Subject: A/31/19/PL

Please find my objection to application A/31/19/PL for 1 house on land between Ashurst and Badgers , Ham Manor Way.

Elevations (1:100)

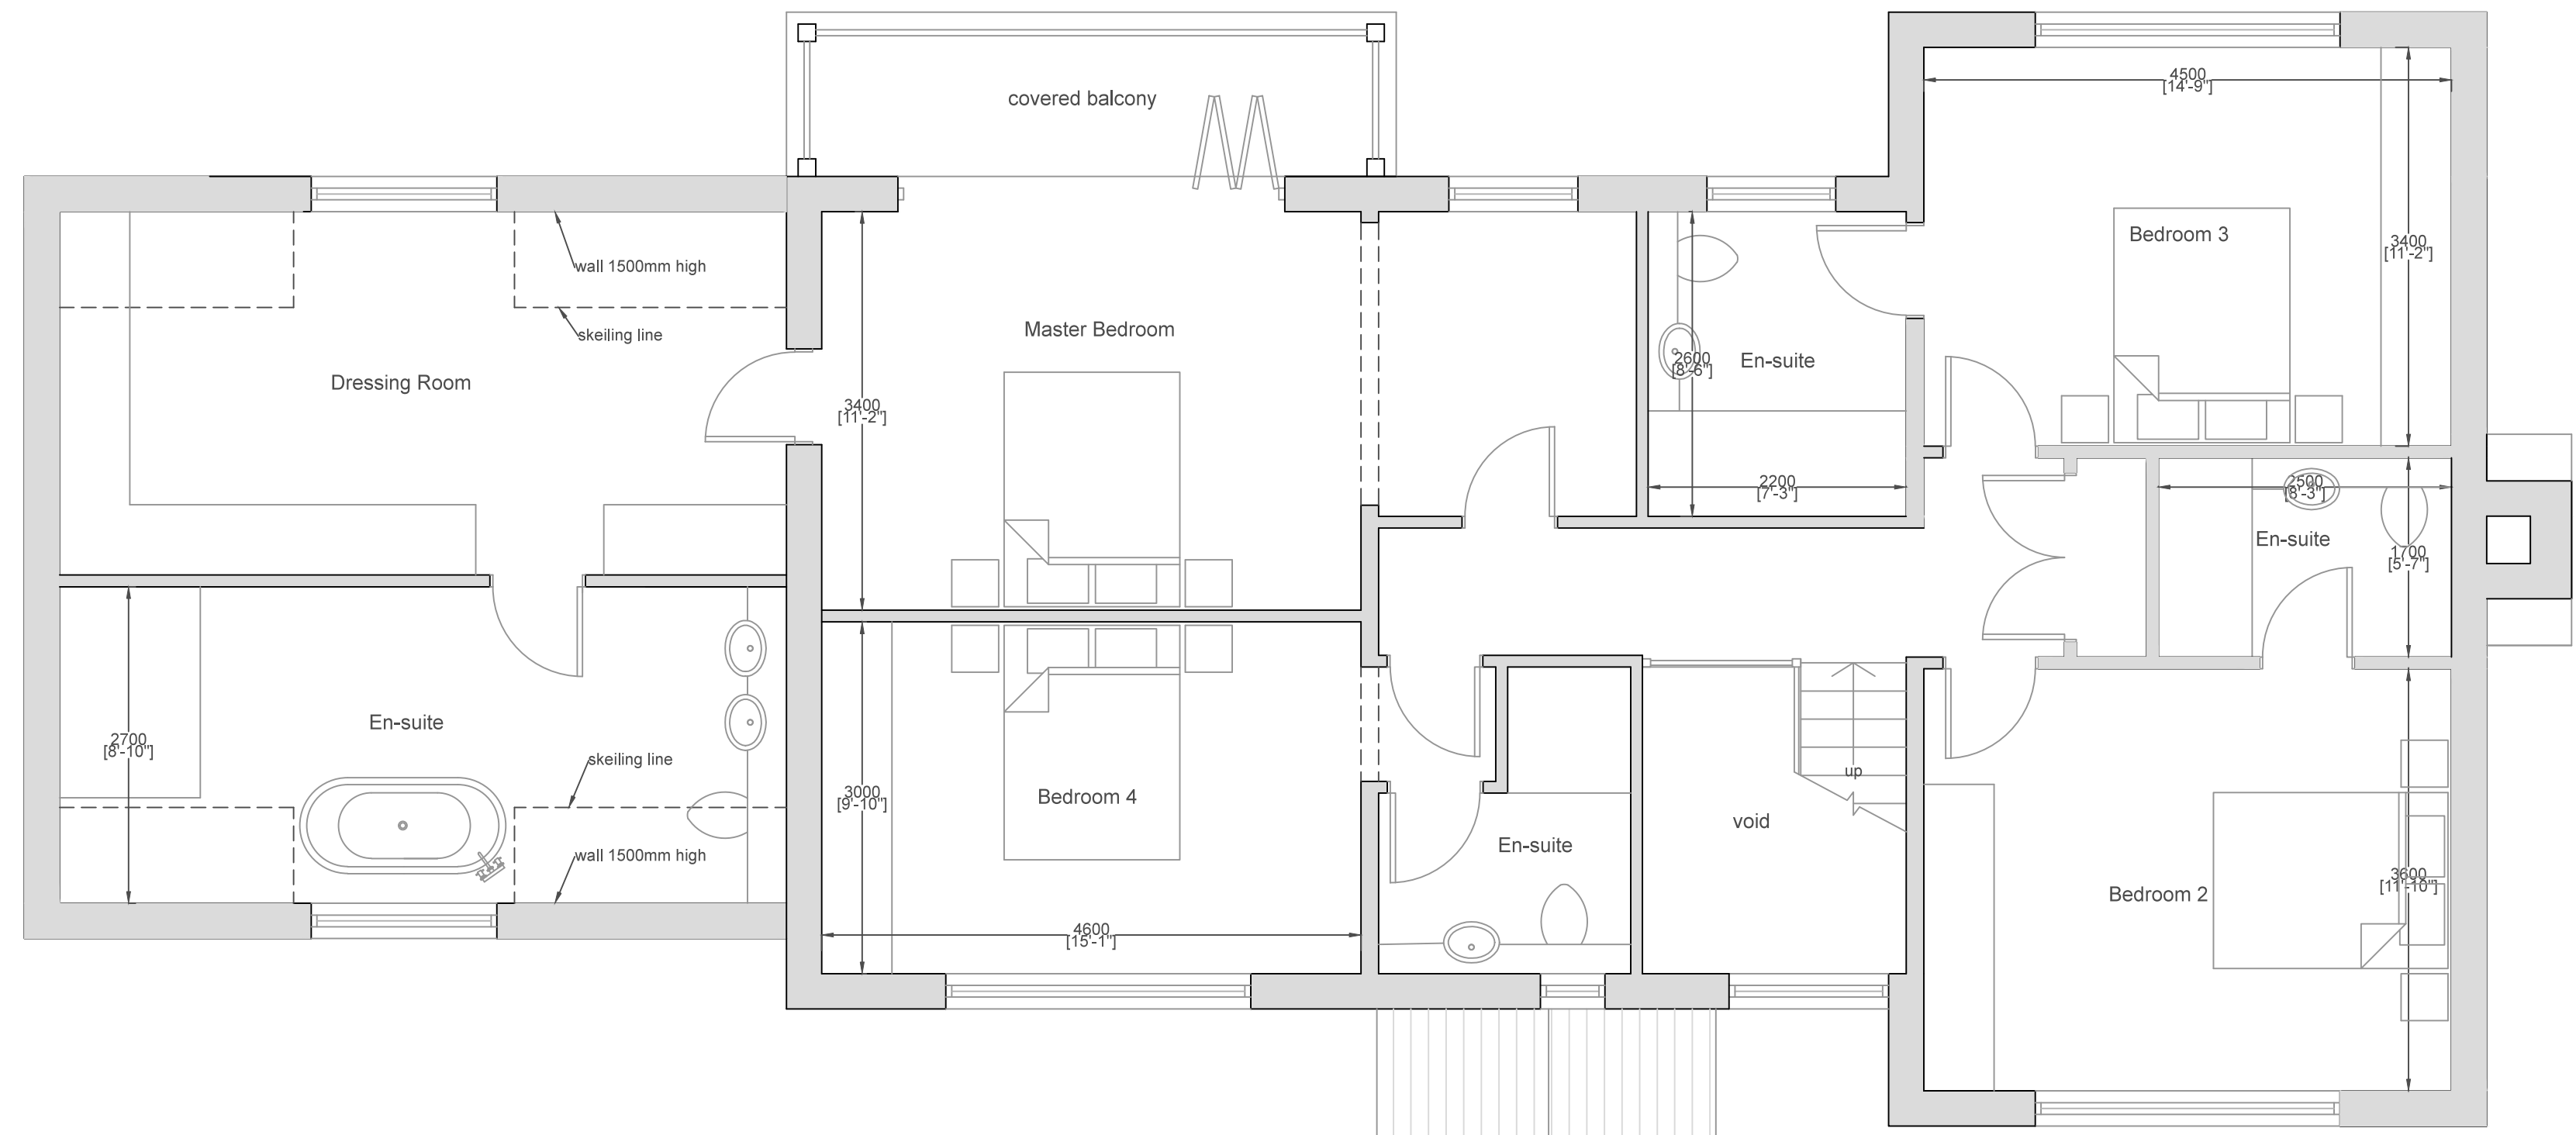
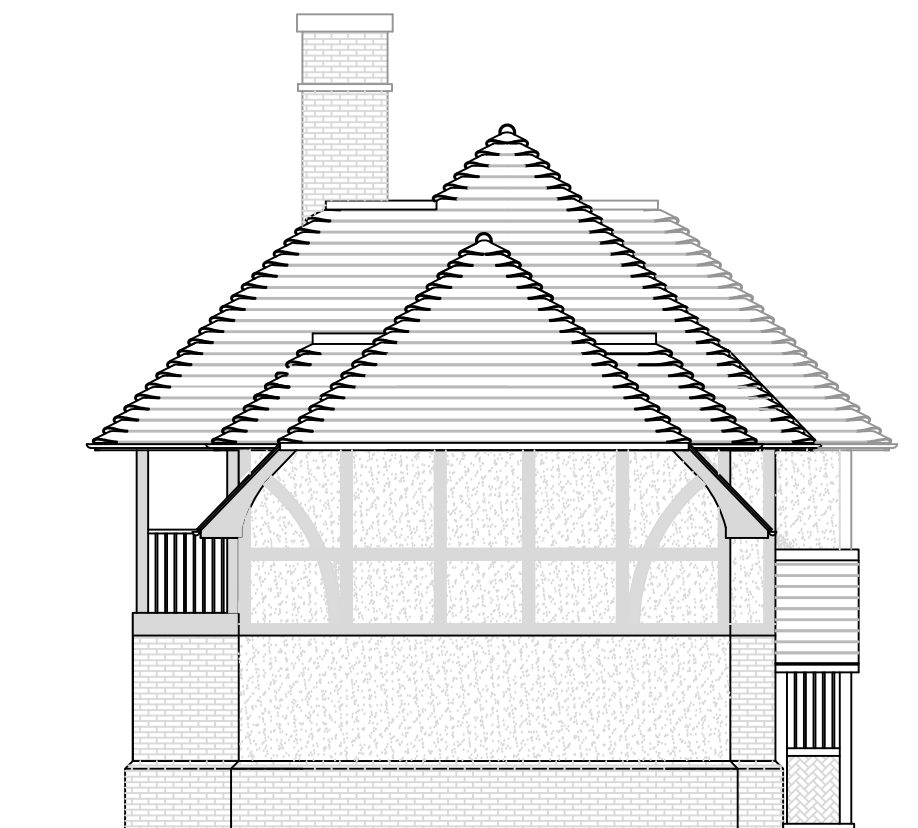
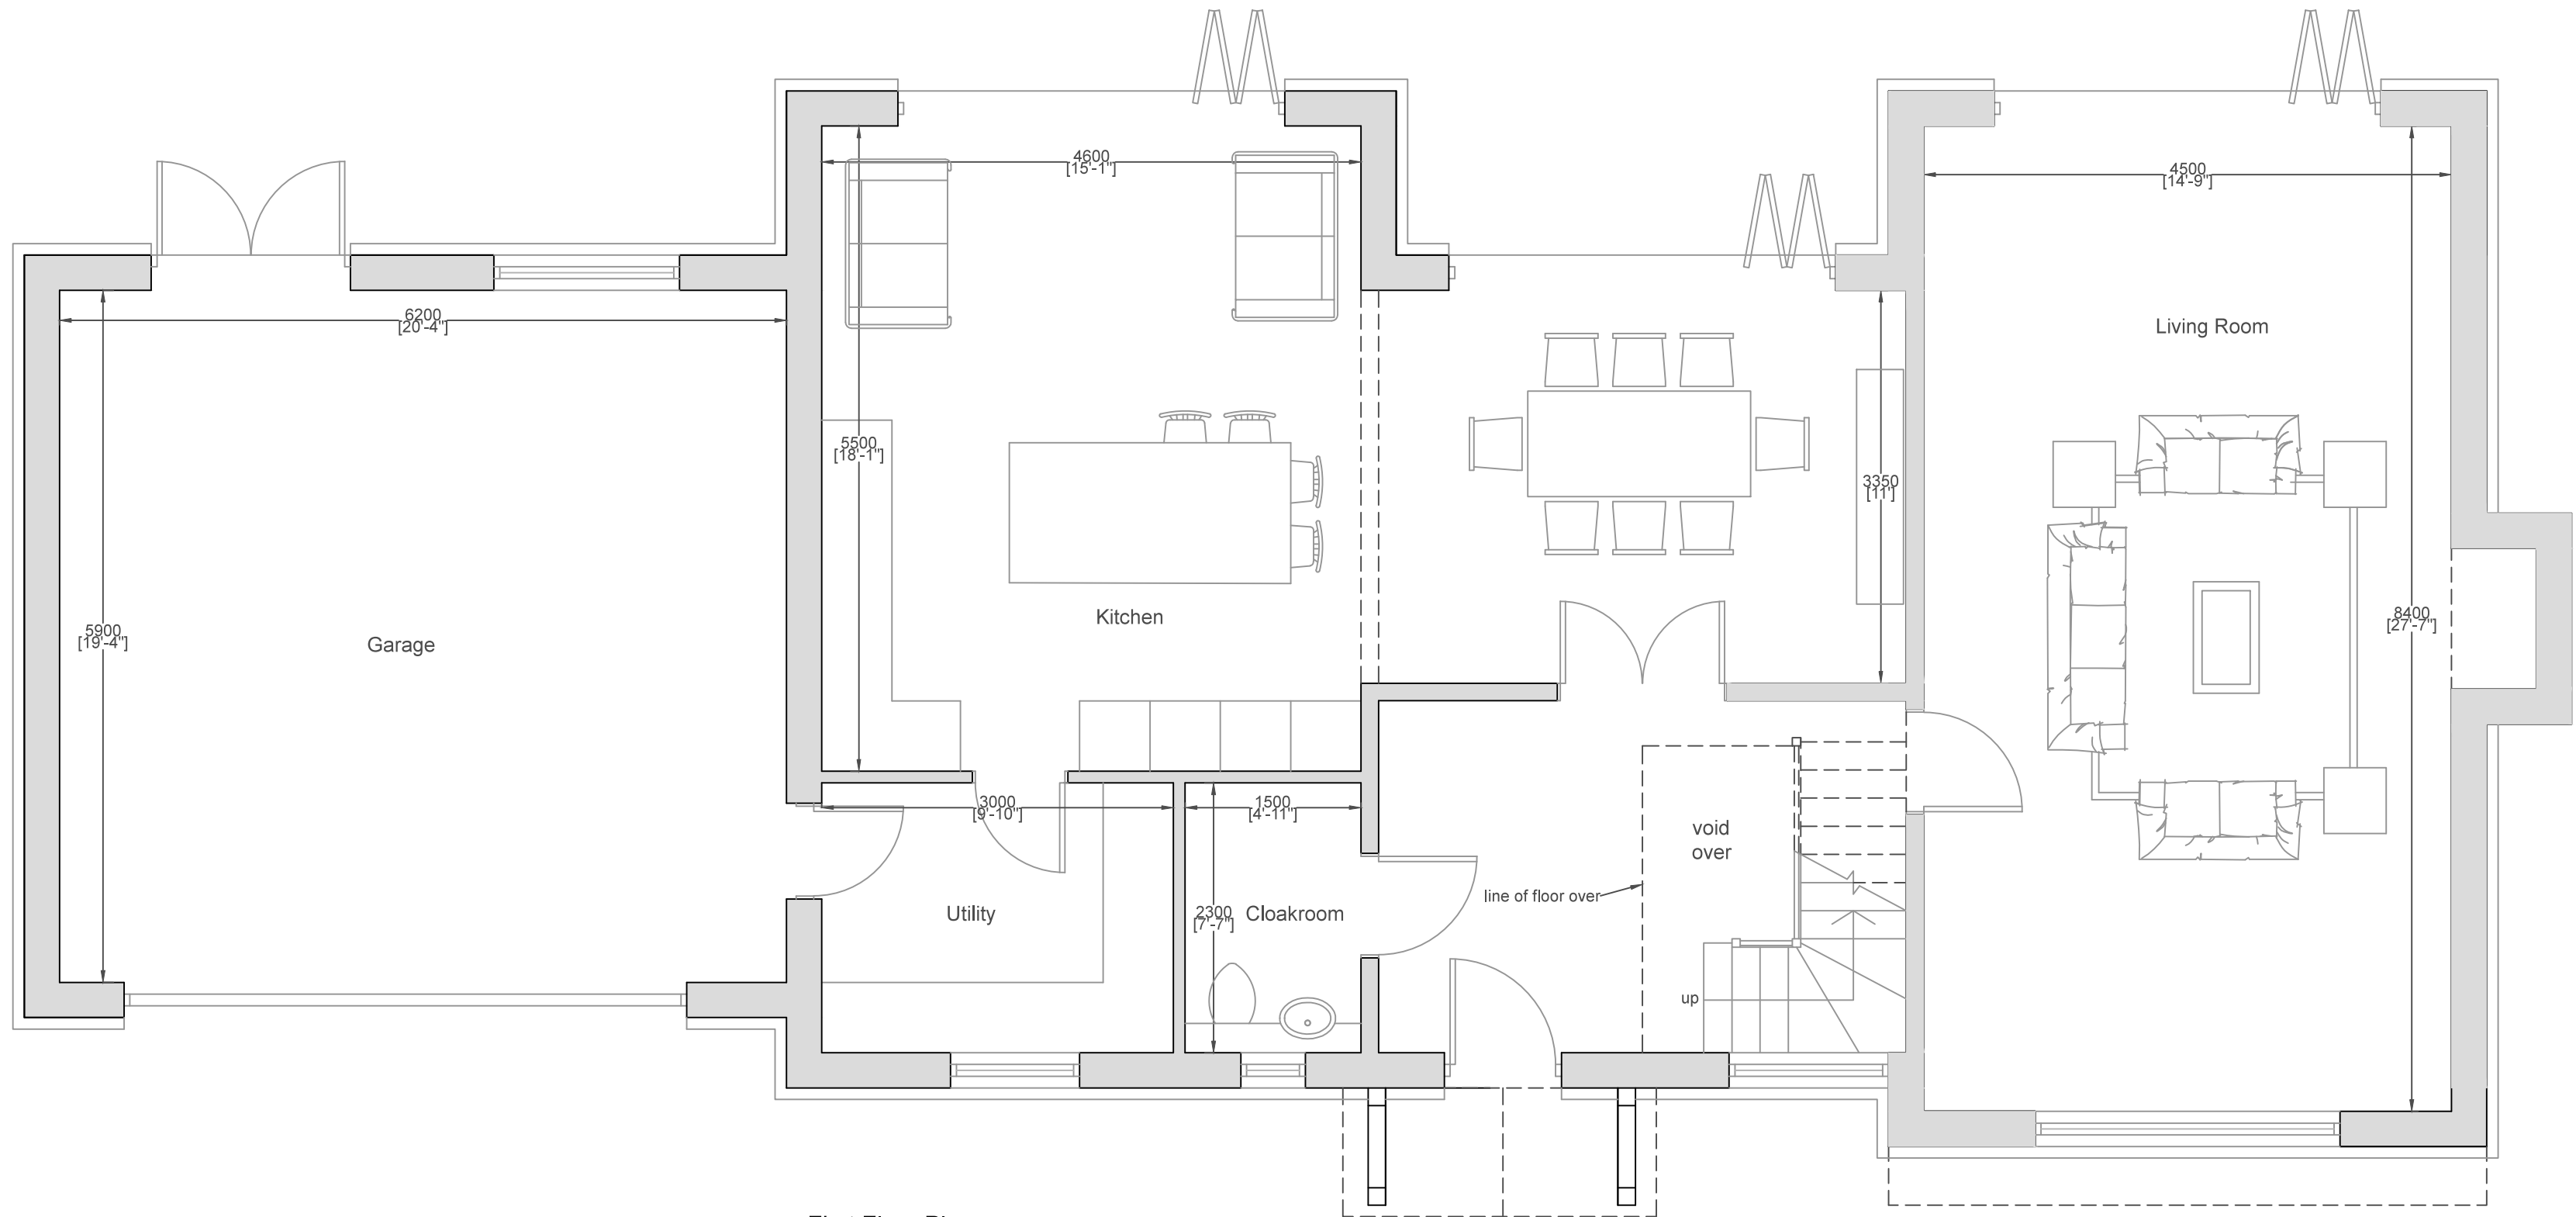
Application A/31/19/PL is a larger house than previously applied for and is totally out of keeping with the Chalet bungalows opposite and those to the south along Ham Manor Way.

There are no windows on the south side of this new property and is quite possible , even inevitable , that a further application will be made at a later stage for development of another large house on plot 8.
Apart from being totally unacceptable to local residents , this would diminish further the distinct rural character of the local area and ruin a unique location and should not be allowed.
